Our Reference: SYD19/01350/12  
Departments Reference: SSD-10448

**RESPONSE TO SUBMISSIONS - ASPECTS INDUSTRIAL ESTATE – LOTS 54-58, DP259135 - MAMRE ROAD - KEMPS CREEK**

Reference is made to the Department's referral dated 9 March 2021 with regard to the abovementioned State Significant Development Application (SSDA), which was referred to Transport for NSW (TfNSW) Services for comments.

PAVEMENT MARKING SCHEDULE	
LONGITUDINAL LINES	
EDGE LINES	
E1	
E4	
E5	
E6	.....LINE APPLIED TO INCLINE FACE OF MEDIAN KERB
BARRIER LINES	
BB	
LANE LINES	
L1	
L7	
CONTINUITY LINES	
C1	
C4	
TRANSVERSE LINES	
GIVEWAY LINE	
TB	
STOP LINE	
TF	
PEDESTRIAN LINES	
PCW	
PAVEMENT ARROWS	
AR3(L)	
AR3(R)	
ARR5

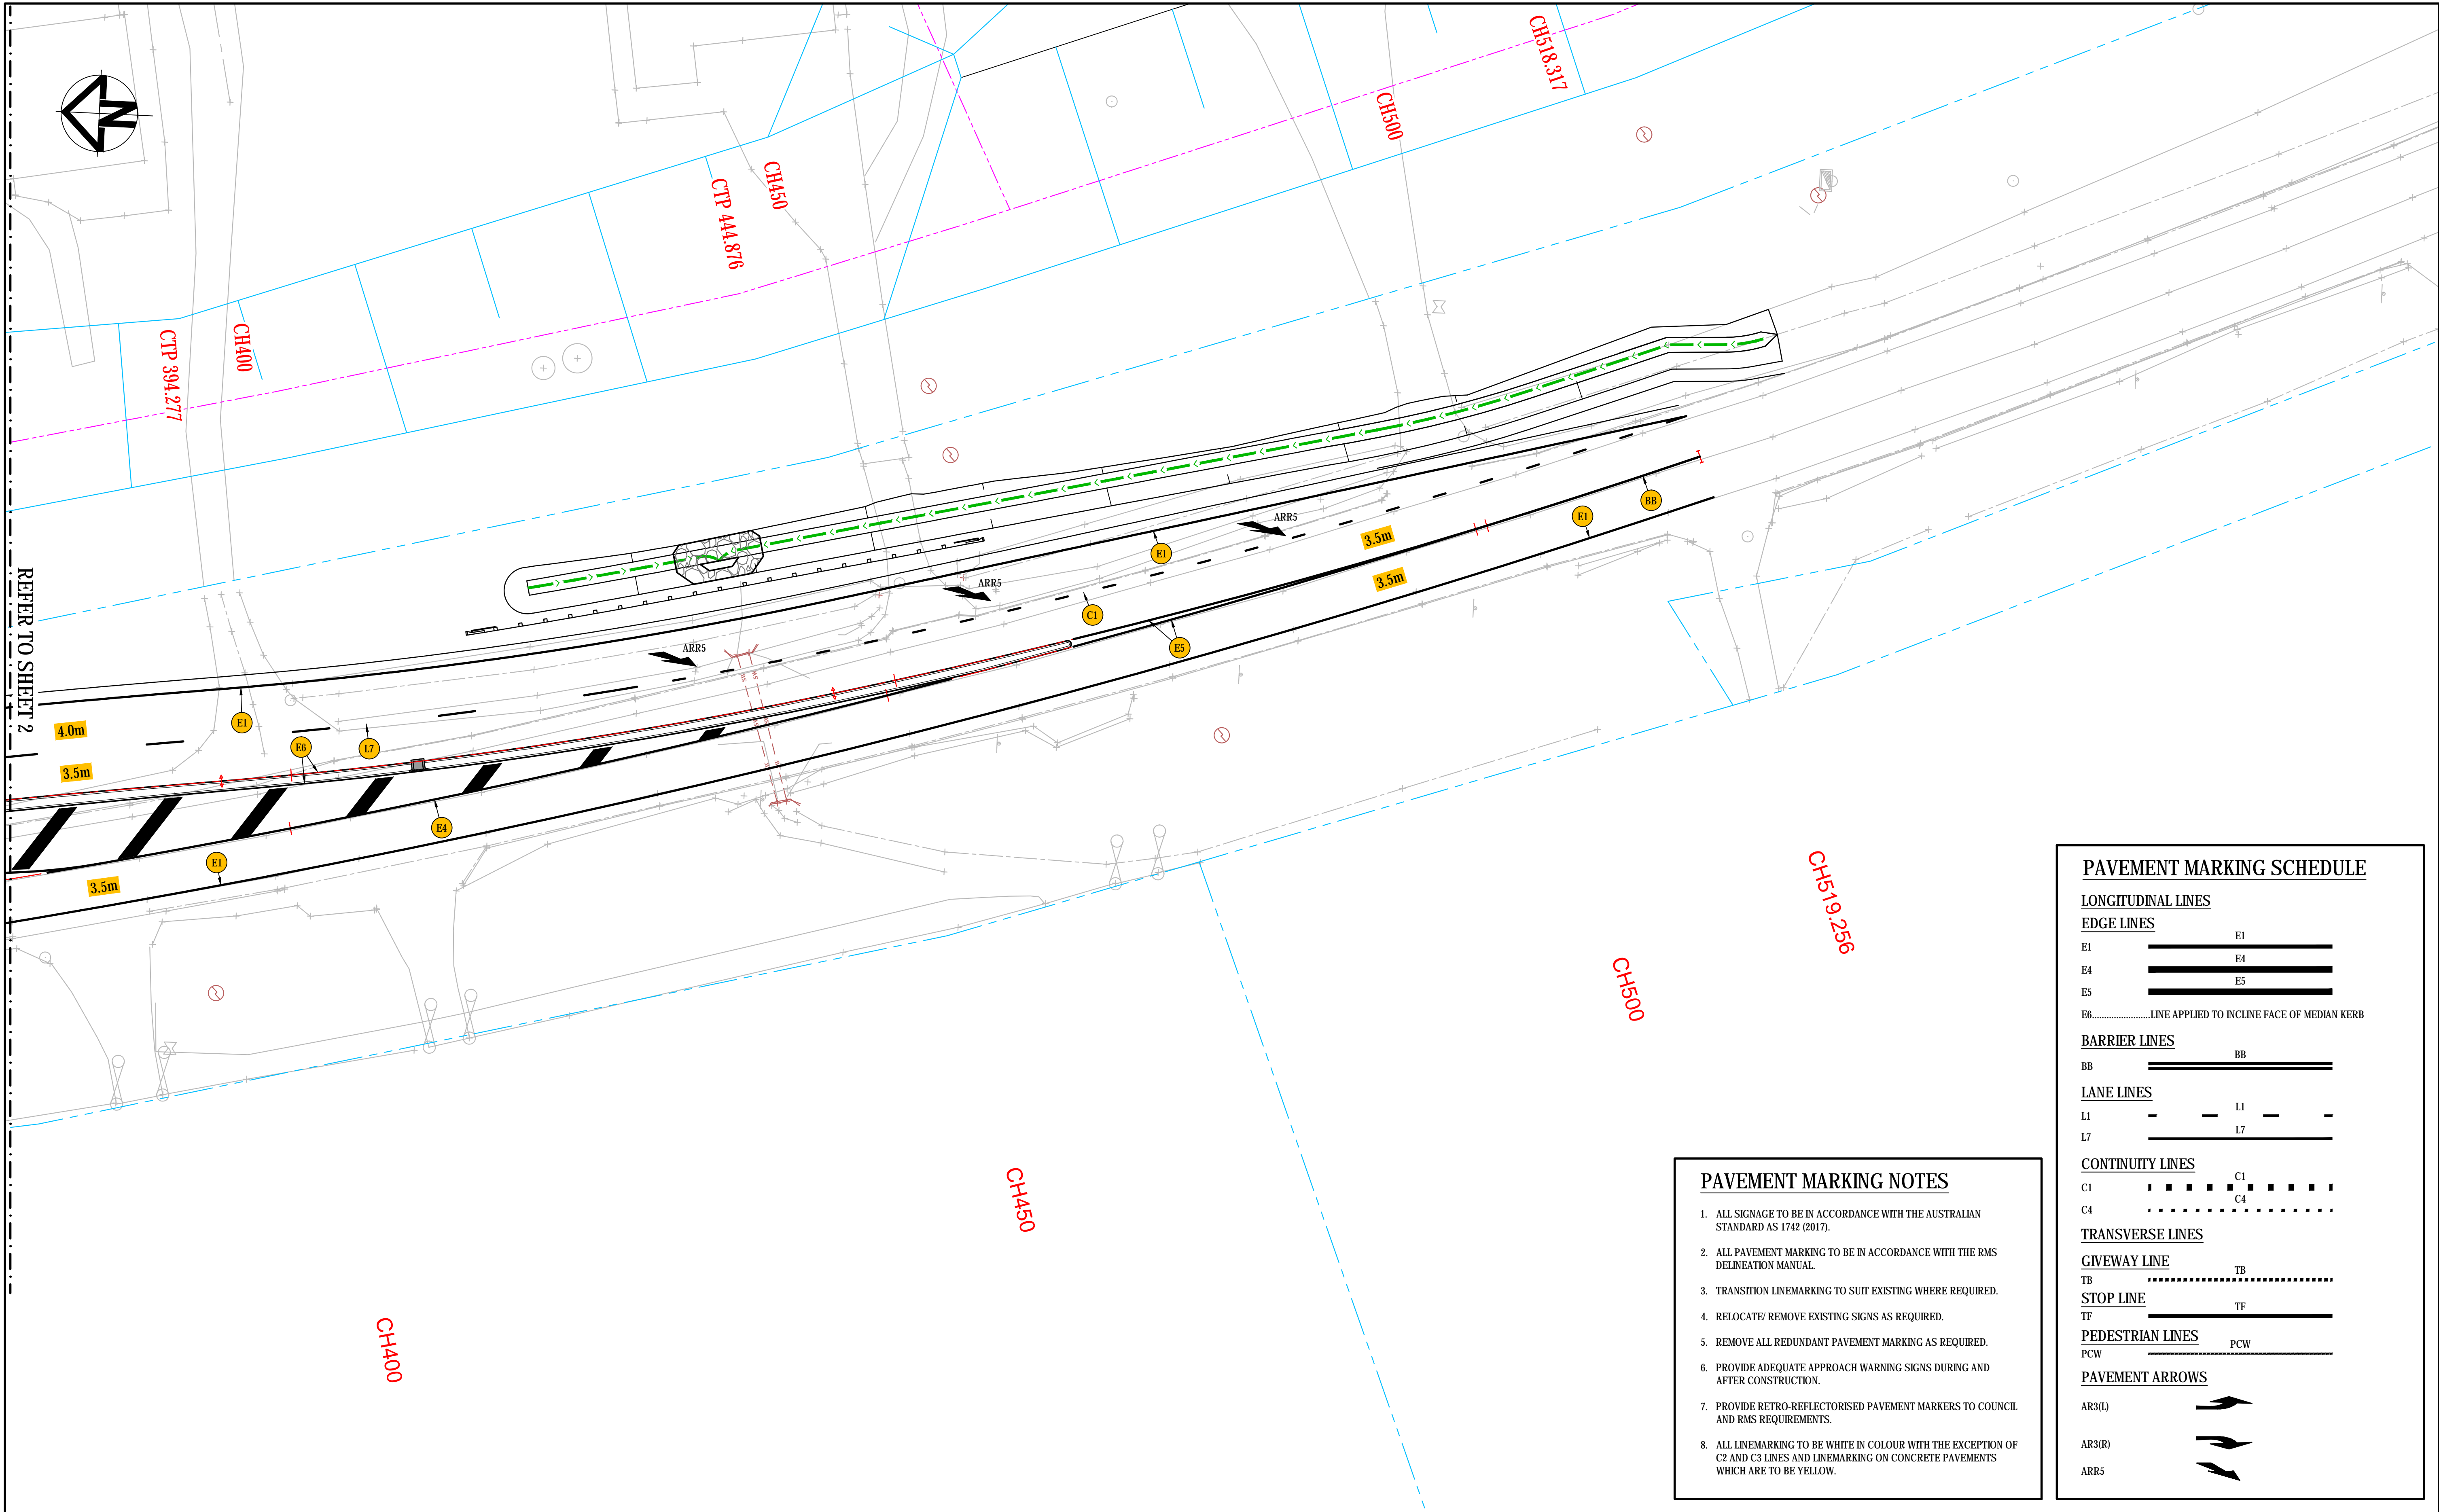
*TfNSW Item 3g* – Further to TfNSW comments provided in the previous submission, when there is no pedestrian activity, an exemption can be requested, so that no installation of lanterns and line marking is required. However it should be noted that the hard infrastructure is still required to be constructed and the geometry is still required for the lanterns and line marking to be included at a later date (if necessary).

Project	ASPECT INDUSTRIAL ESTATE MAMRE ROAD, KEMPS CREEK STAGE 1
Title	ROADWORKS AND STORMWATER DRAINAGE SHEET 1

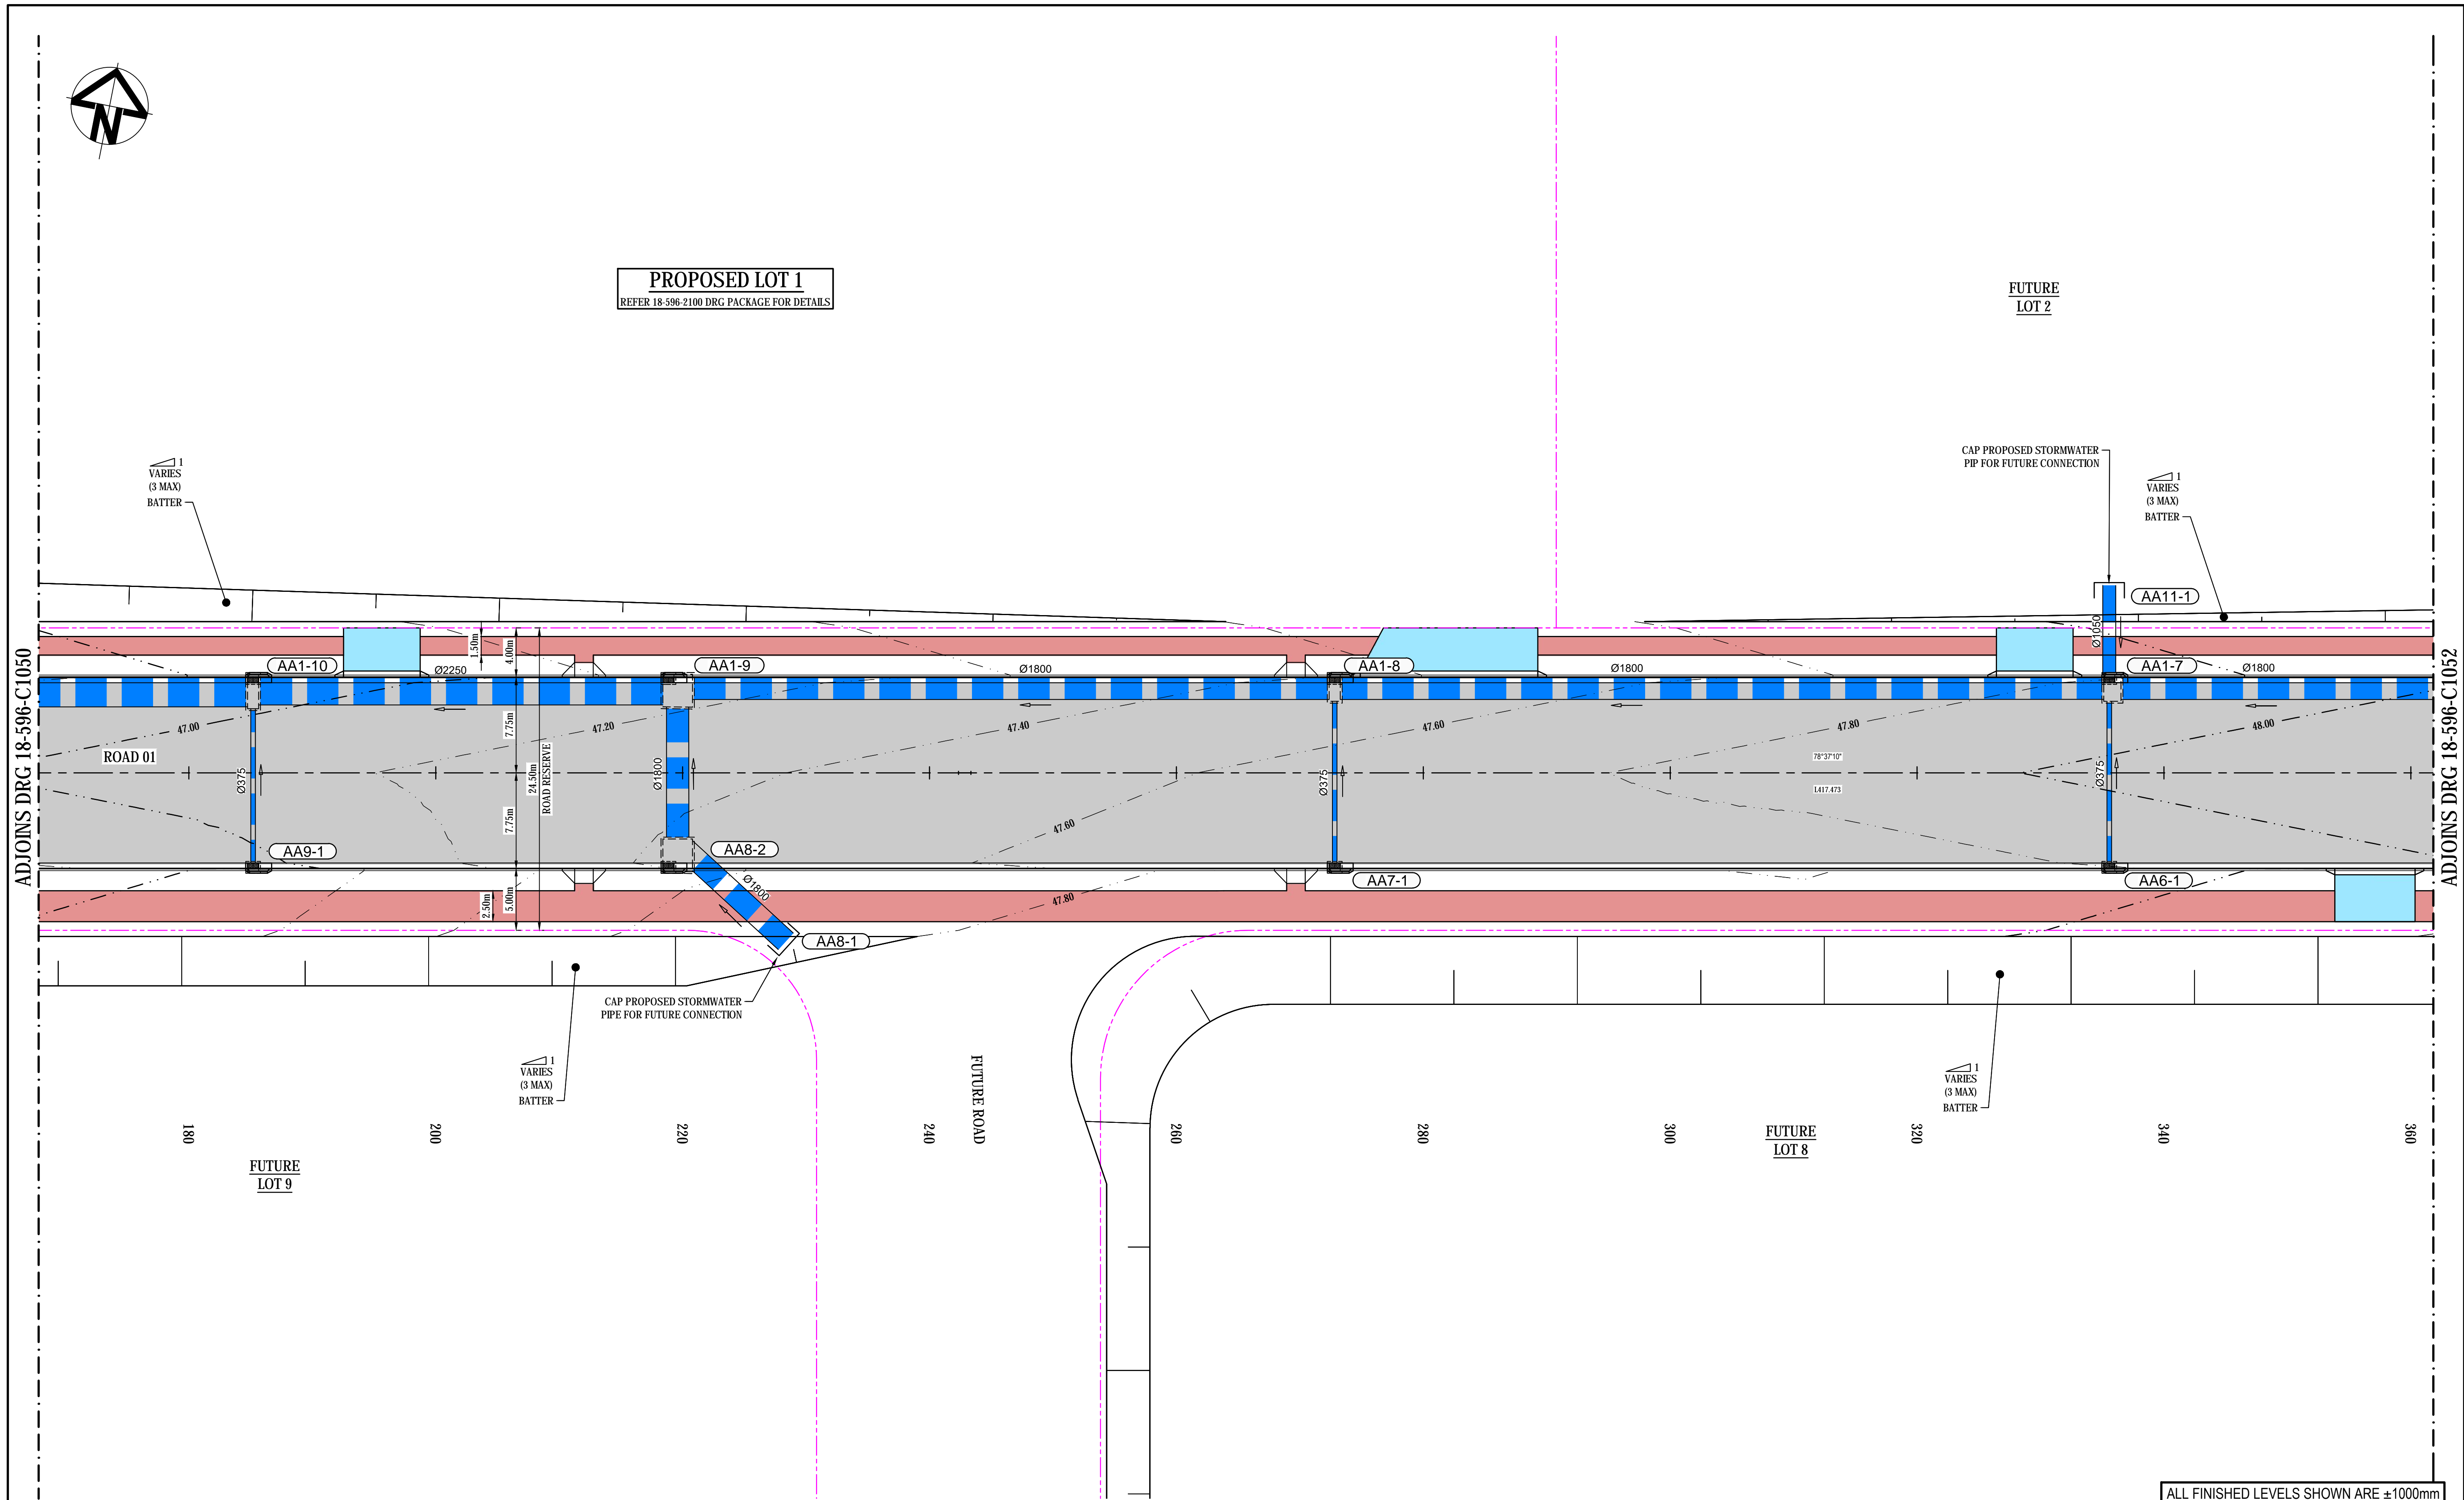
TfNSW notes that the Road 1 is a “High Order Road” or primary (collector) road as stated in the Mamre Road Precinct DCP. The DCP also states *Driveways should be provided from*

*lanes and secondary streets rather than the primary street, wherever practical.* In this regard TfNSW would not support multiple access points along the collector road Road 1.

In addition the access point to Warehouse 1 carpark is located in close proximity to the proposed signals and would not be supported.

It is recommended to consolidate individual sites to reduce fragmented road side activity. Site consolidation should keep direct access to the collector roads to a minimum. Reducing conflict points along the collector road will support traffic efficiency and safety.

Warehouse 1 has access to the minor road Access Road 1. All accesses to the development should be from this road.
